**Re: Liverpool City Council Submission SSD-10446 Resource Recovery Facility
275 Adams Road, Luddenham**

Comments on Resource Recovery Facility - 275 Adams Road, Luddenham**1. Strategic Planning Context**

DRAWING TITLE
LANDSCAPE GENERAL
ARRANGEMENTS PLAN
SHEET 3

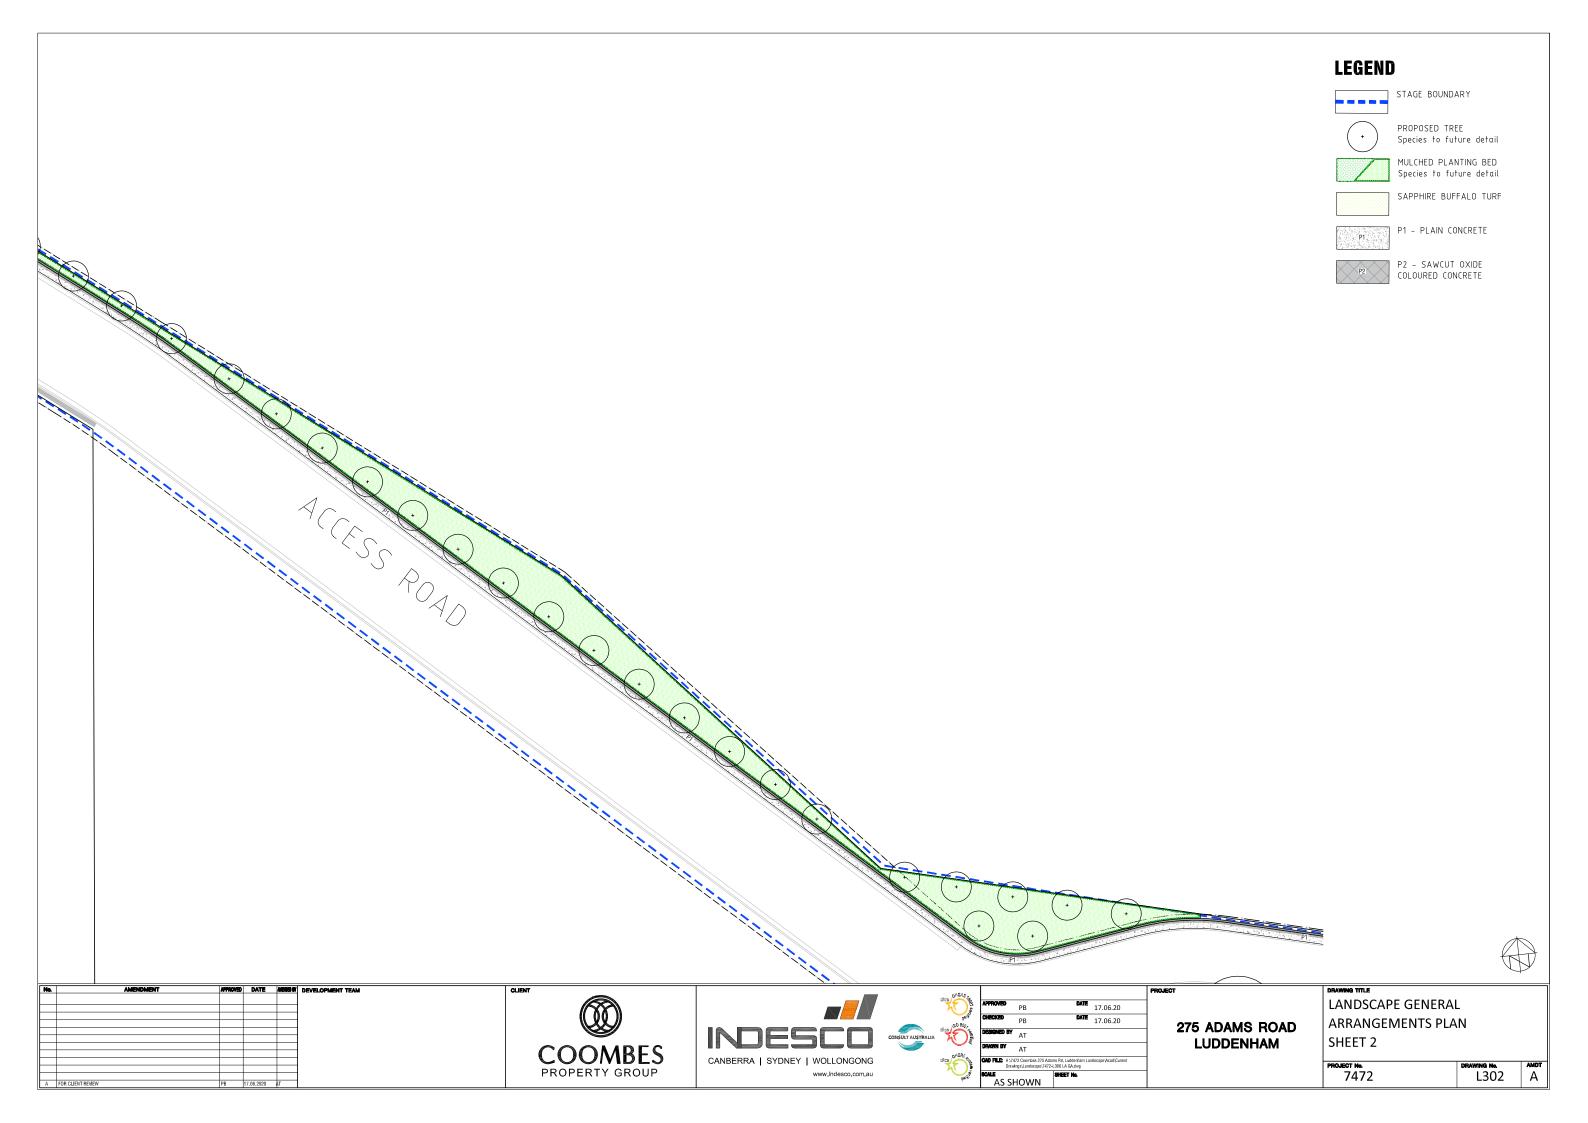
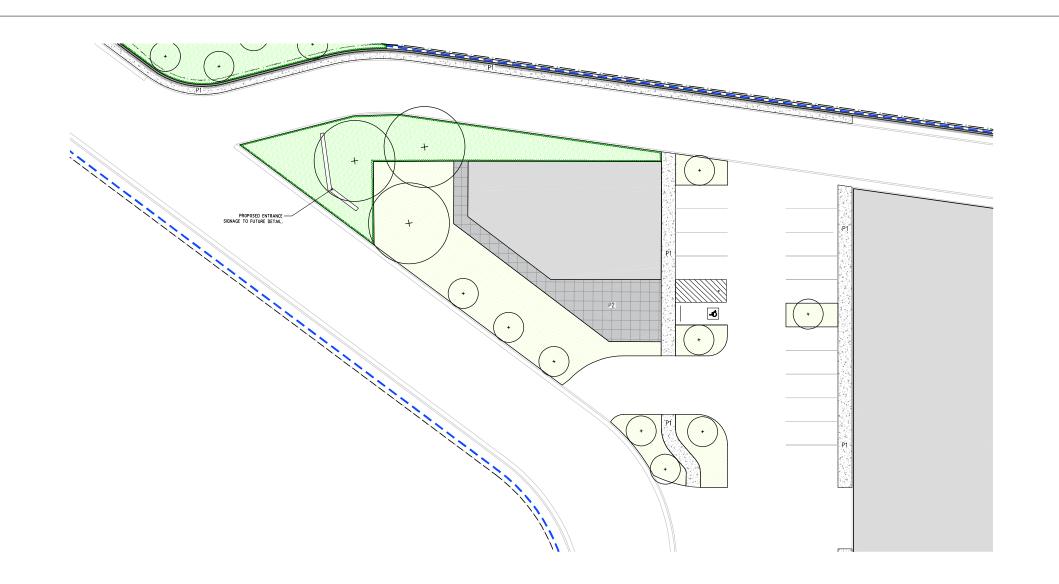
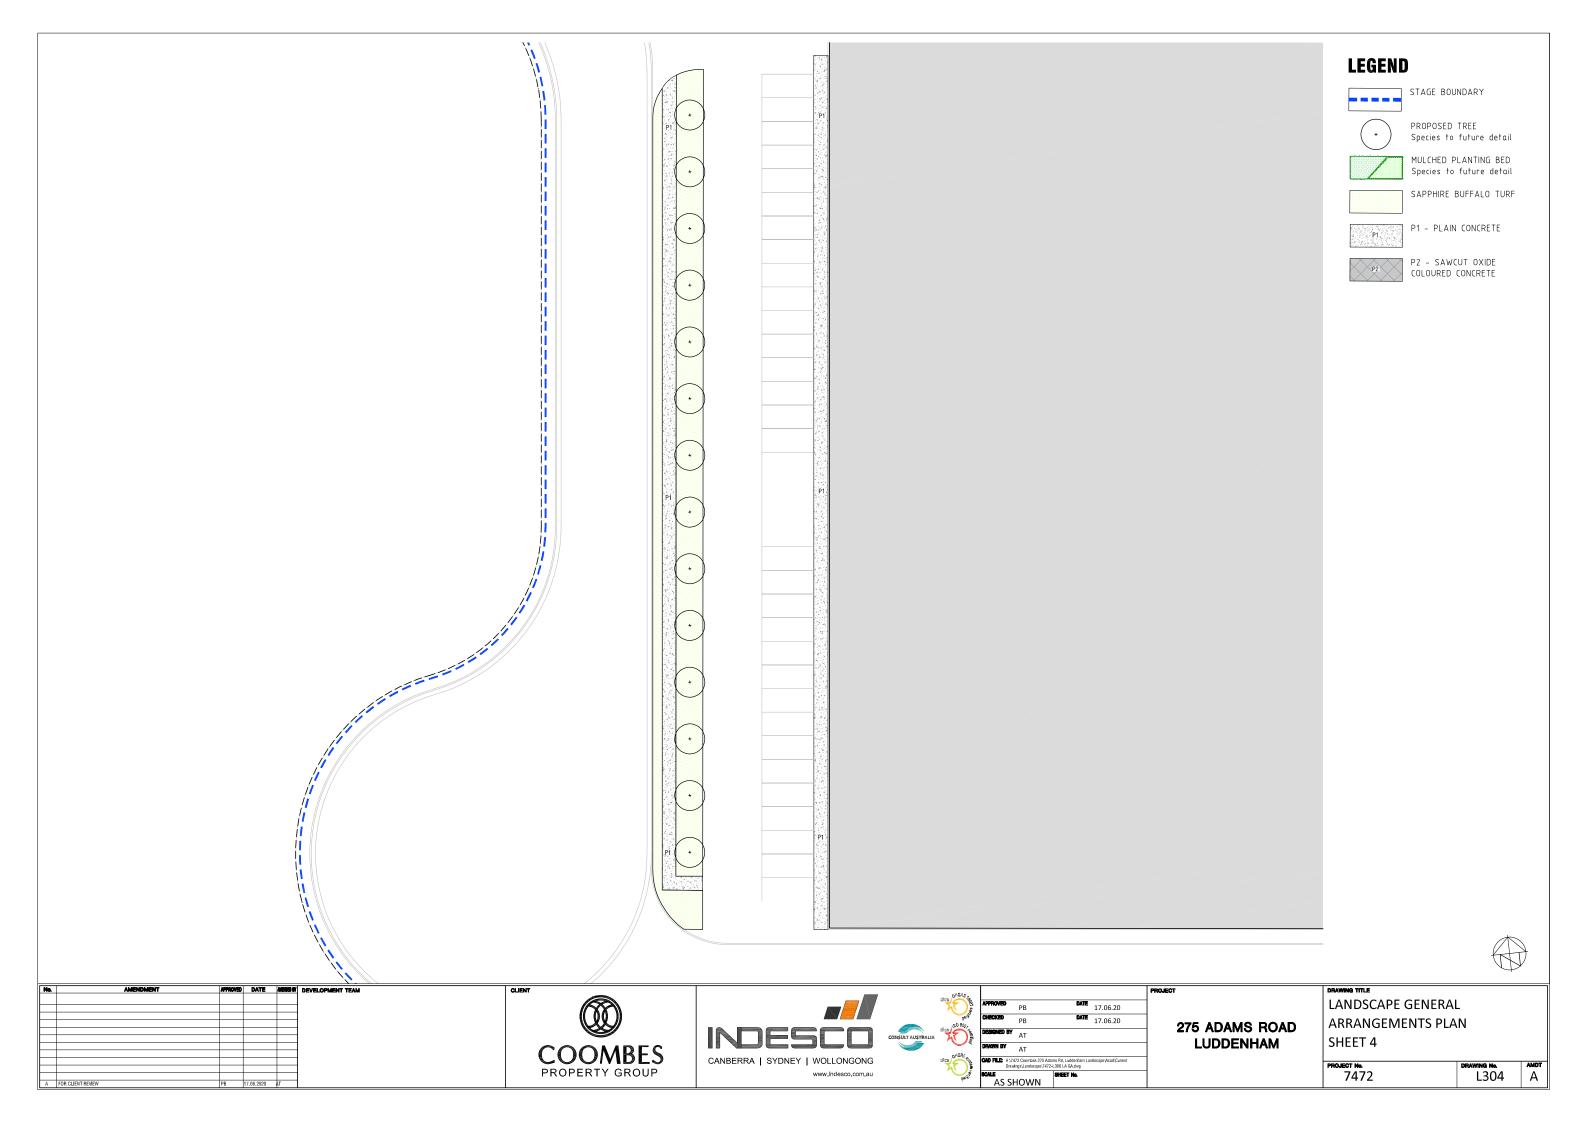
- The Landscaping Concept Design Plan (205687.2020) identifies the proposed use of a small tree (*Acacia longifolia*) in an orderly lineal planting layout. This species has a fairly short life potential and is generally more appropriate for use in bush regeneration/revegetation projects. If these trees are used in a formal setting they are likely to require replacement after 5 to 10 years. Recommend revised choice of species.
